Subject: Fwd: objection to BR/222/18/PL

Objection to planning application **BR / 222 /18/PL**

I wish to **STRONGLY OBJECT** on proposed development as I am (and my family) worried about:

First floor plan

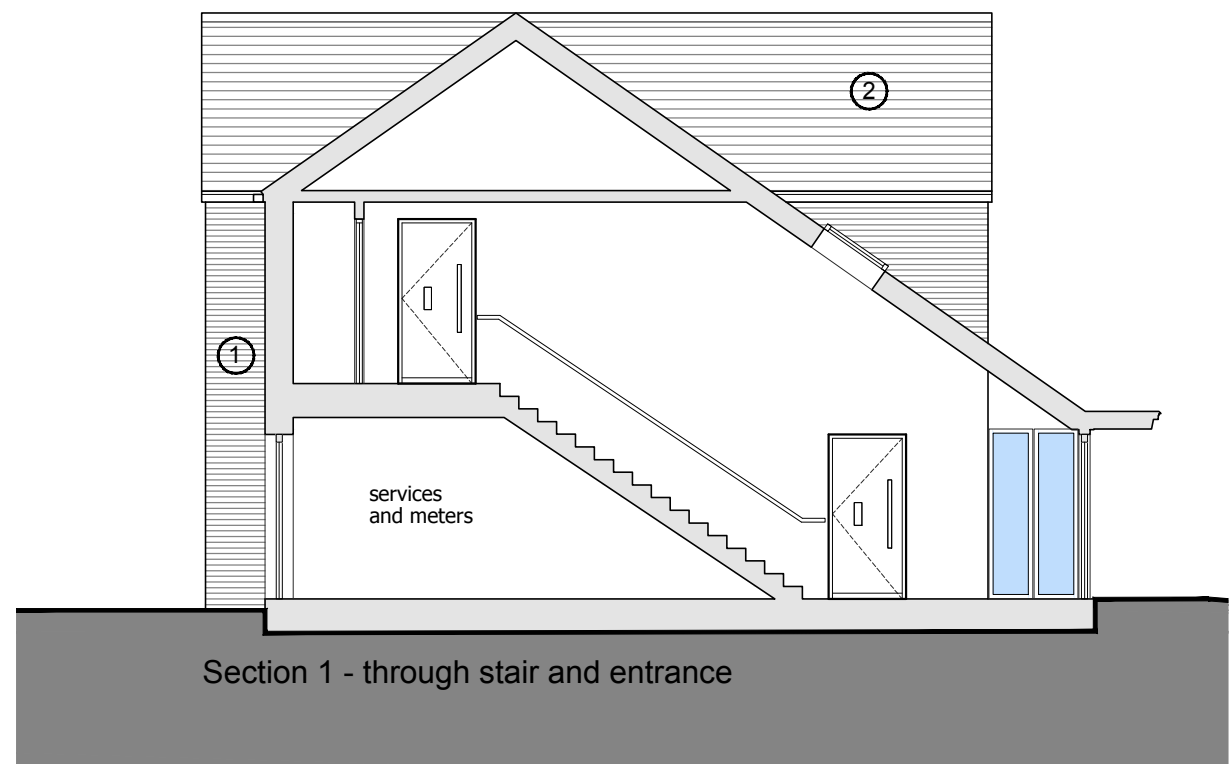
- **Overlooking/Mainly loss of privacy.** The proposal is for two storey building. Northern facing secondary 1st floor lounge window should be removed to stop overlooking our garden. We have bought our house because it has got this beautiful garden where we have enjoyed our time in private.
- **Loss of light or overshadowing.** The proposed house is going to be **twice as long** as my house. This building will block all sunlight which we get in to kitchen and hallway through our doors and window on south site wall. Also this building will block lots of sunshine in our garden.
In planning application are gables which I think should be replaced with sloping tiled roof to lessen the impact.
- **Loss of green area (trees, shrubs).** As stated above we thought this would be a communal garden hence we have invested our time and money to plant different plants on plot.
